Project: Retail Tenancy 5 – Overseas Passenger Terminal

Report: BCA & Access Assessment Report

Reference No: 107134-BCA-r5

Date: 2 May 2017

Level 1 Proposed
1:200 @ A3
July 2016
SK
257_ADA_012 F

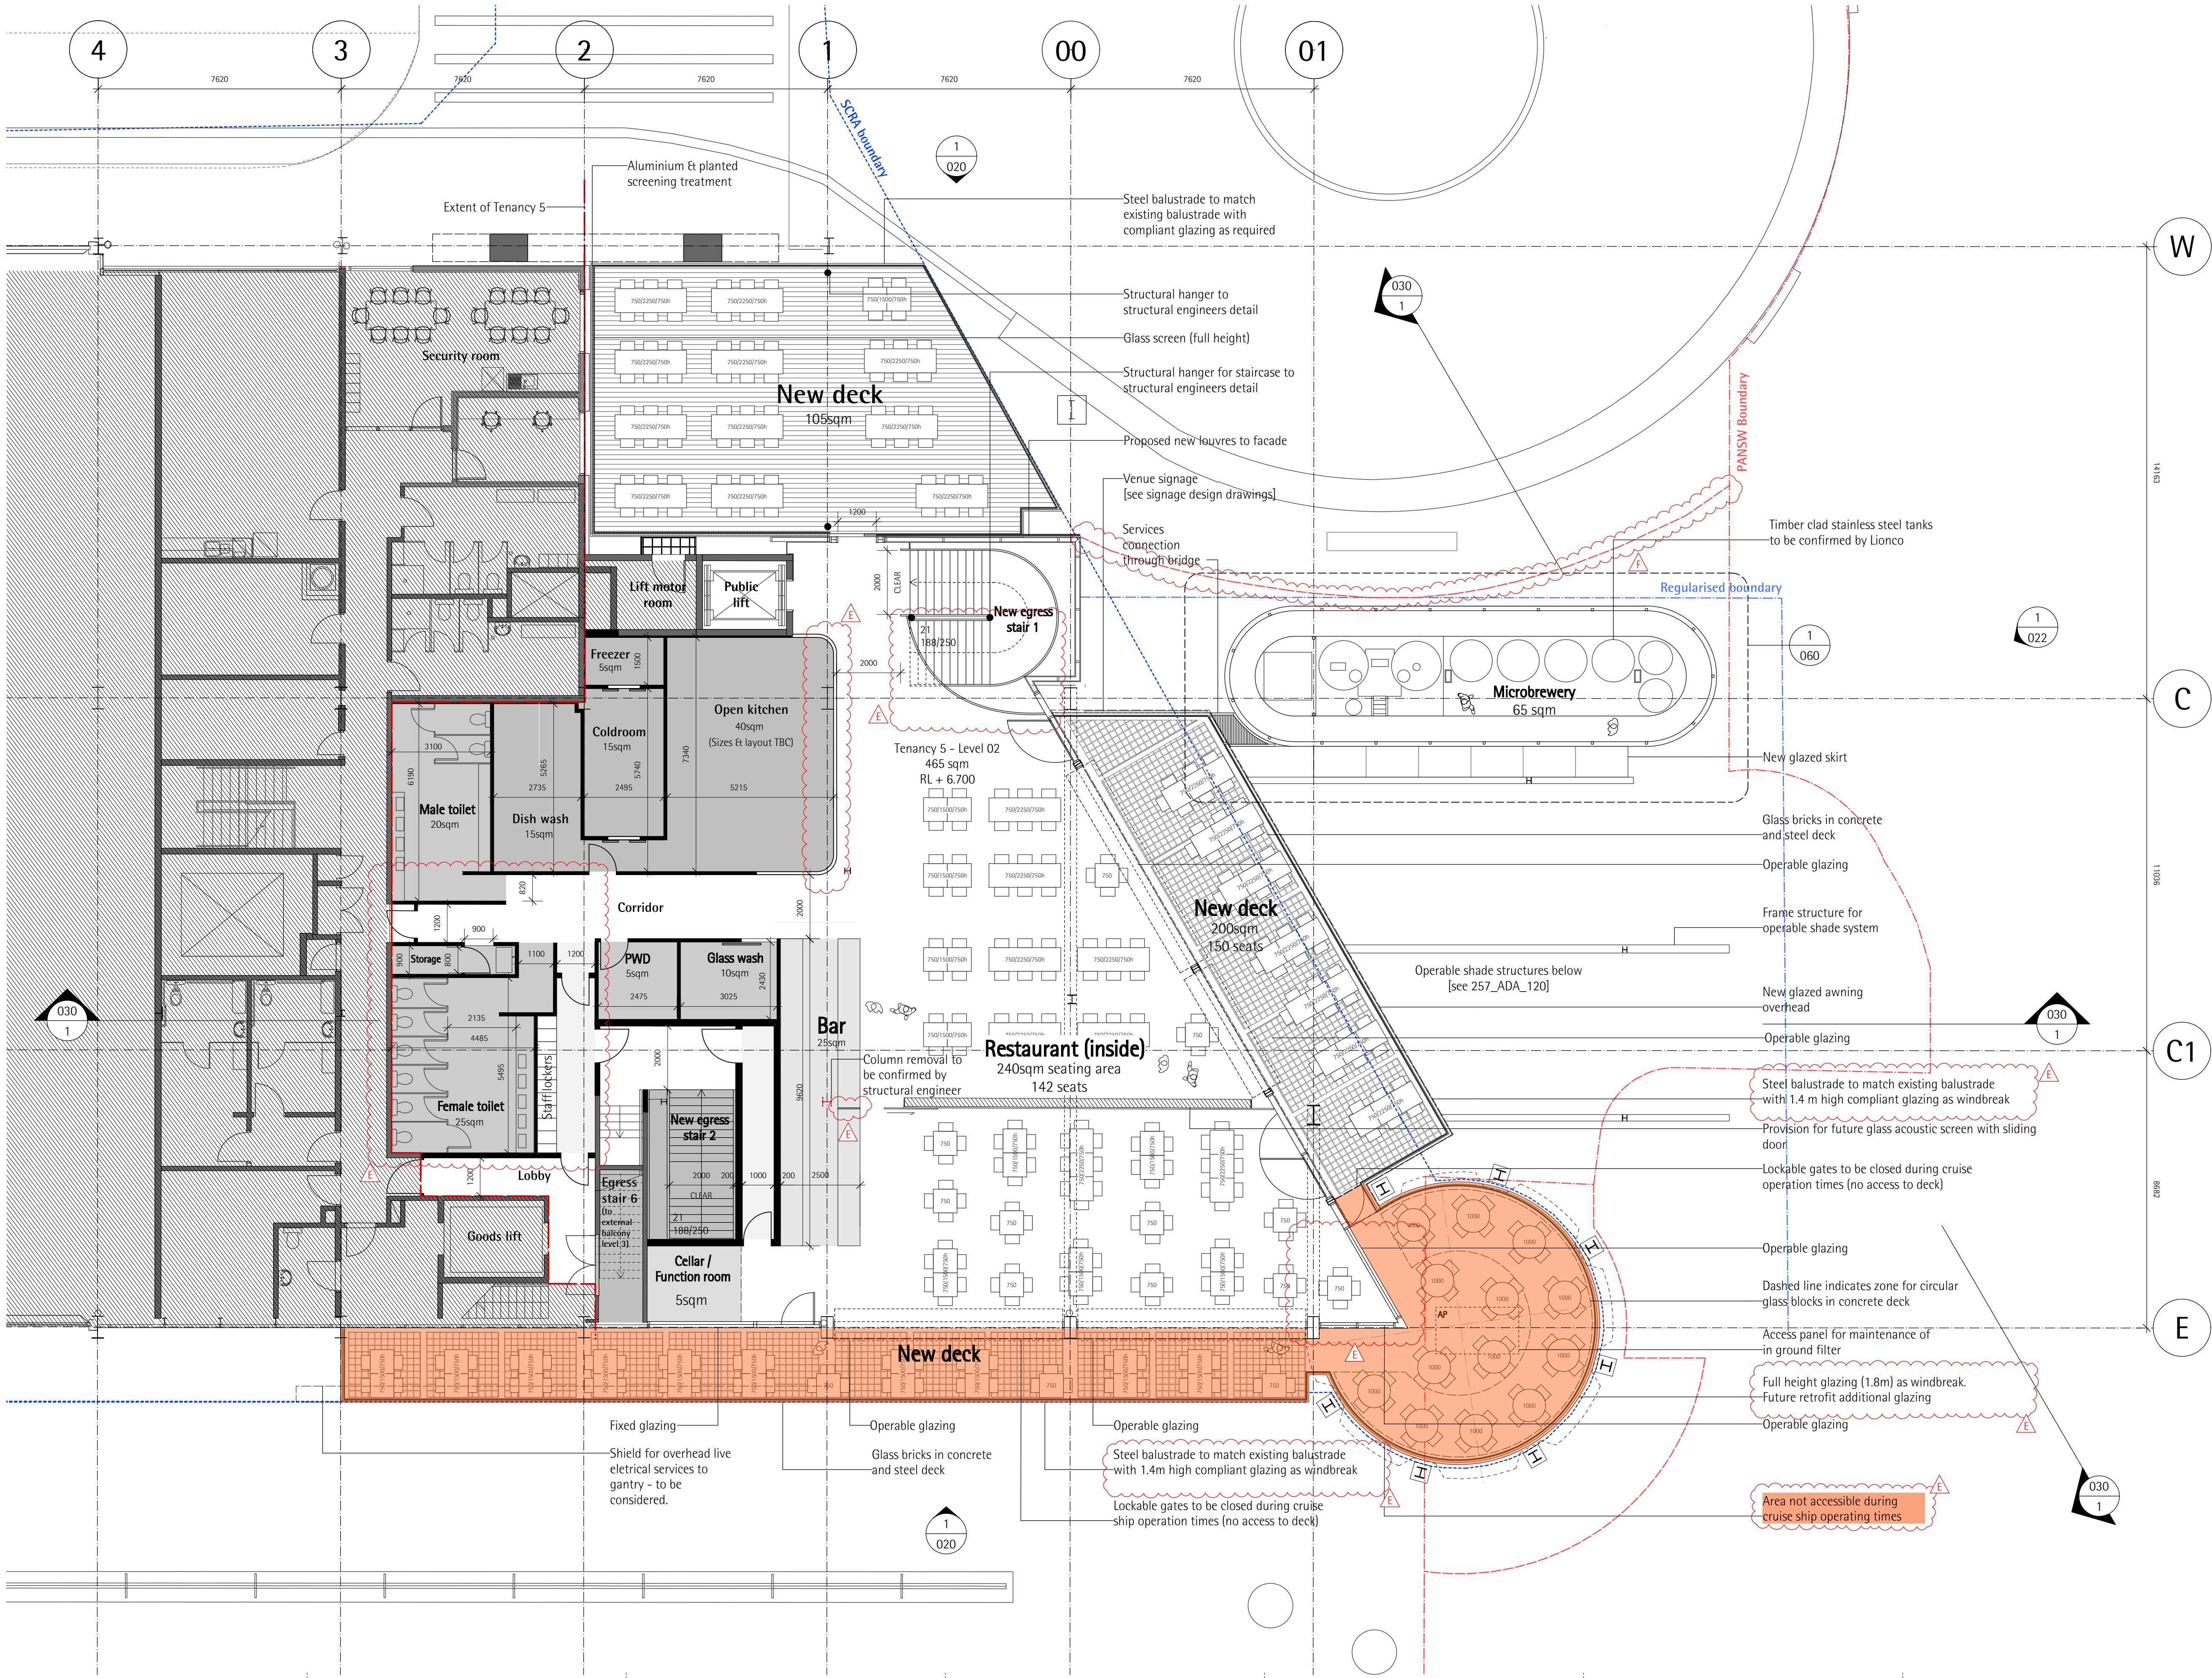
Under Table 3 of BCA Specification C1.1, external columns not incorporated in an external wall are required to achieve an FRL of not less than 180/–/–. The four new external columns proposed at Level 1 do not appear to be fire-rated. It is recommended that BCA compliance be achieved via a Performance Solution in lieu of fire rating the columns.
